**CITY OF ALBUQUERQUE
PLANNING DEPARTMENT
November 19, 2014
DRB Comments**

PROJECT # 1007099

APPLICATION # 14-70378

RE: Lot A1A, Blocks 16 & 17, Zuni Addition

MENAU BLVD. N.E.  
(100' R/W)

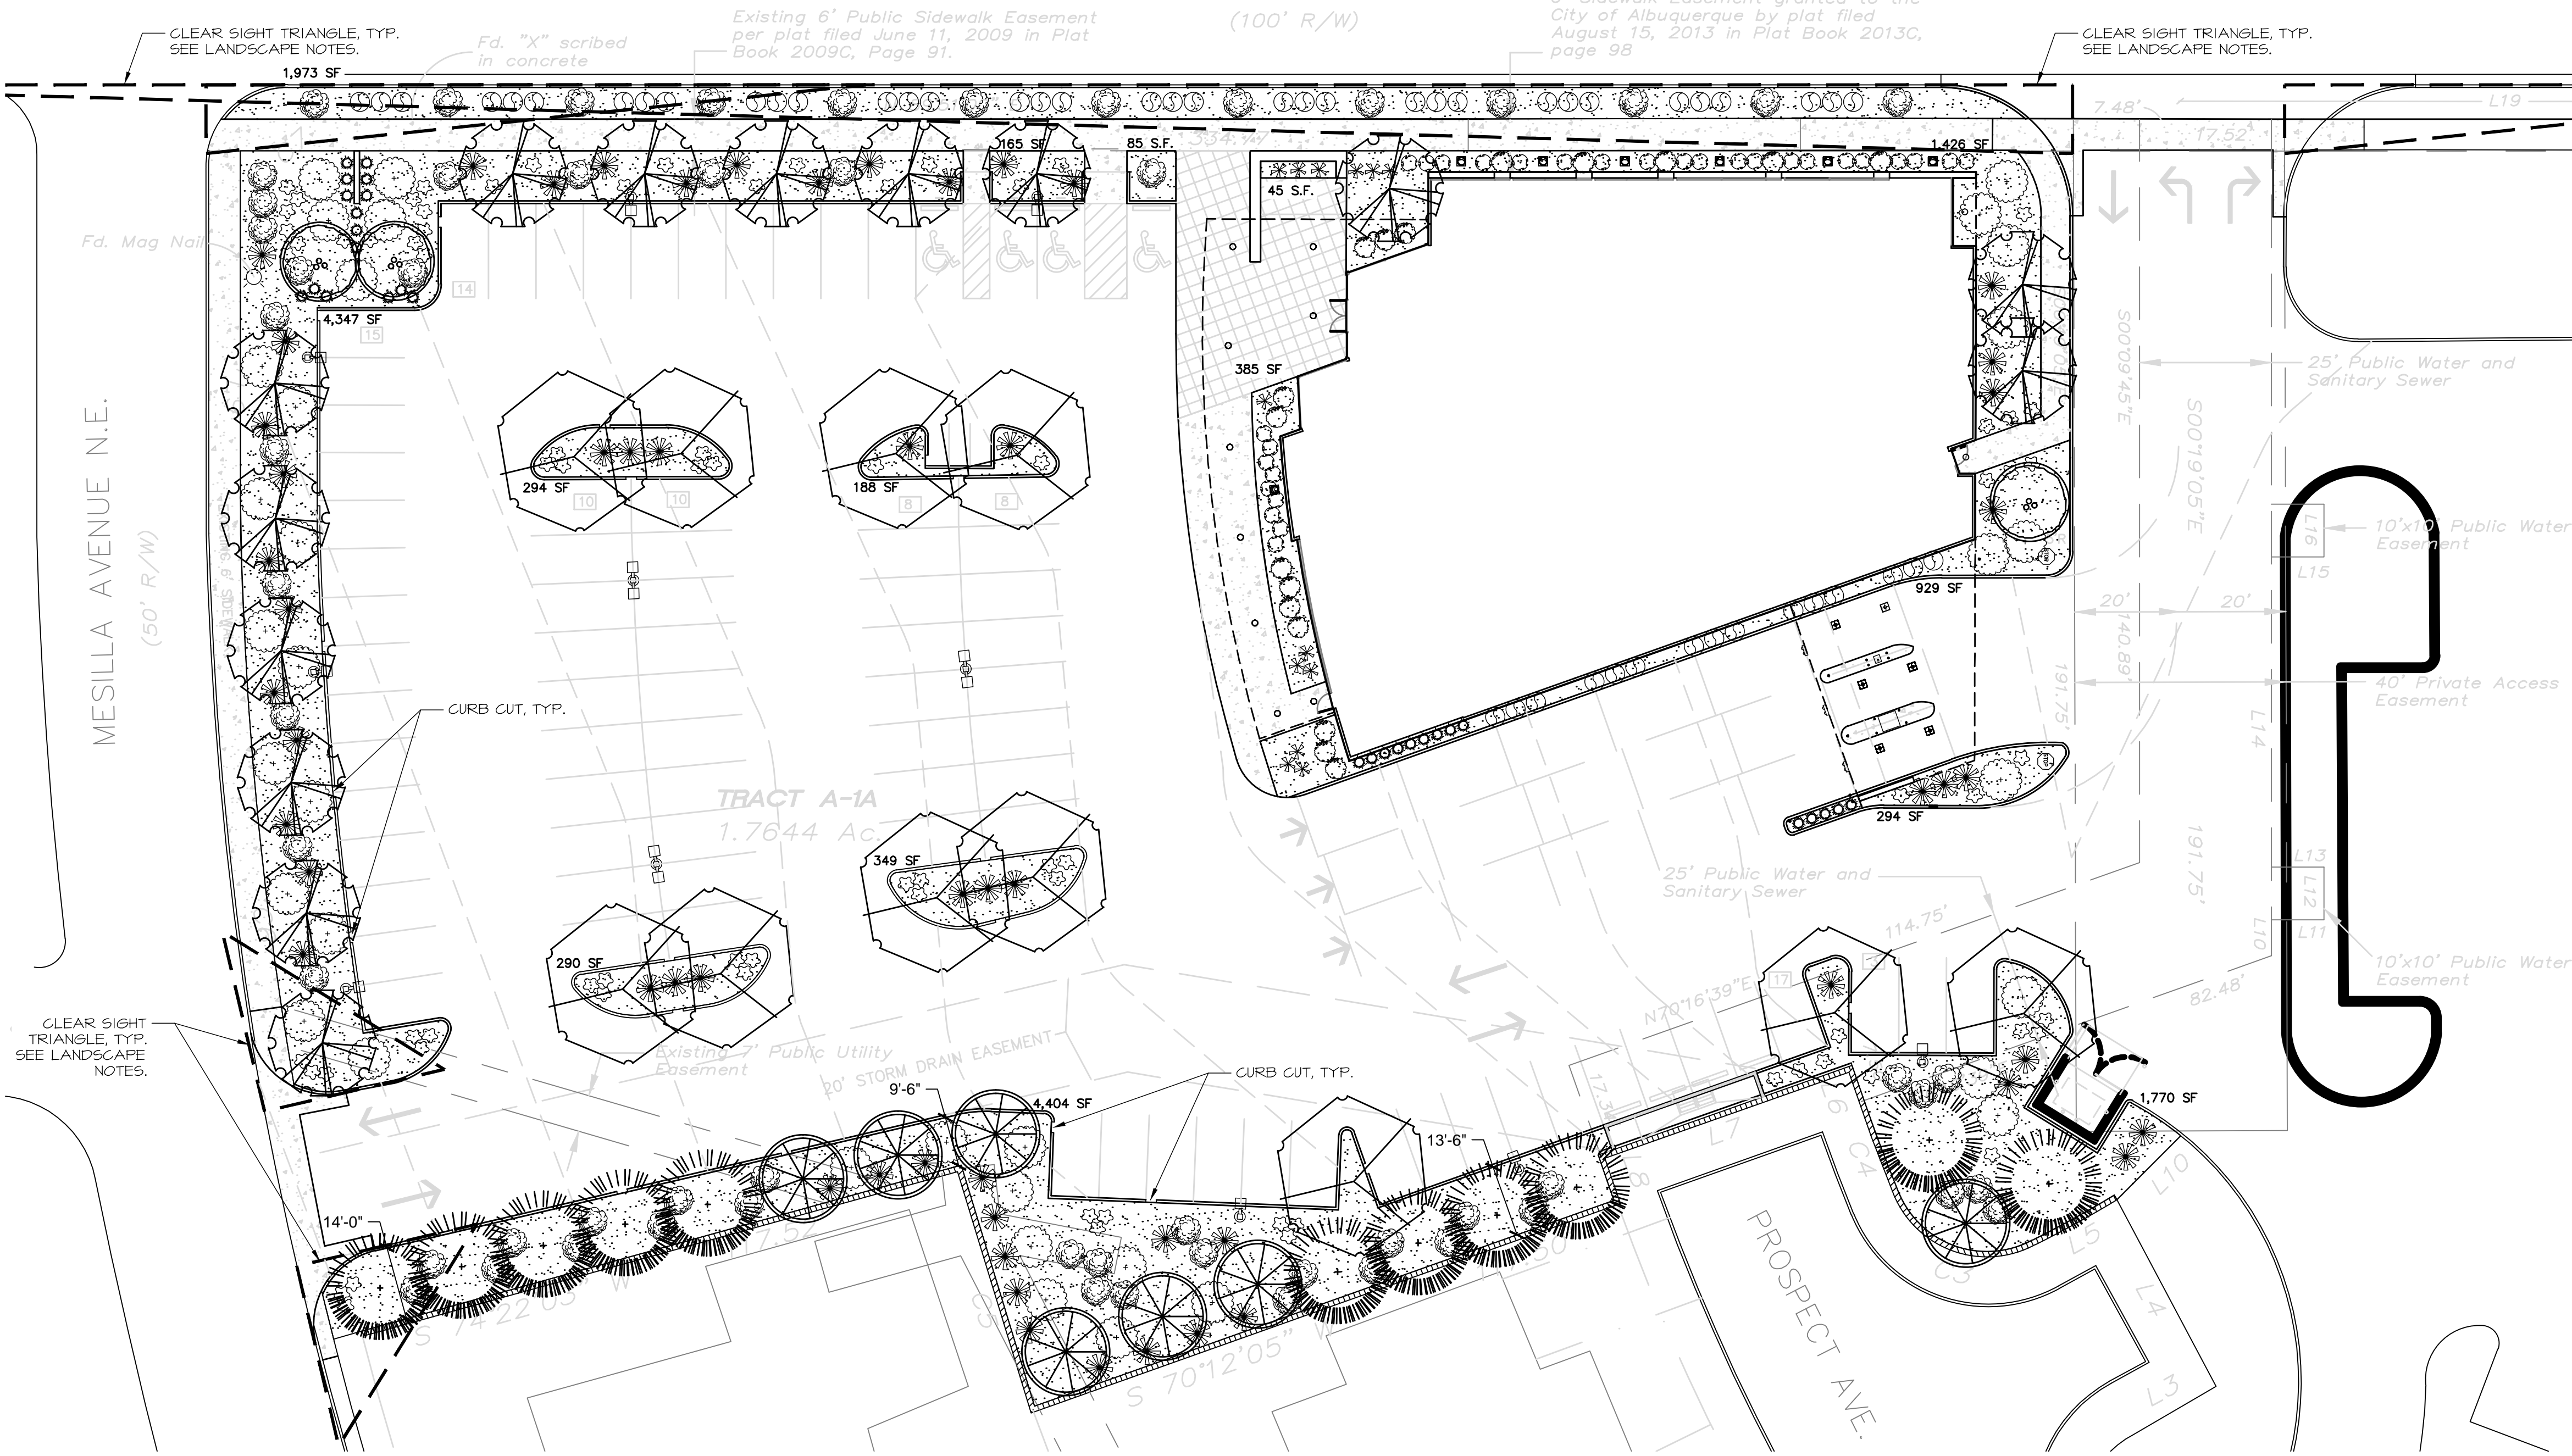
The revised plan needs to be reviewed with the EPC Case Planner; the revised response still did not correct the calculation for bench seating (it appears the bench corners are being counted twice).
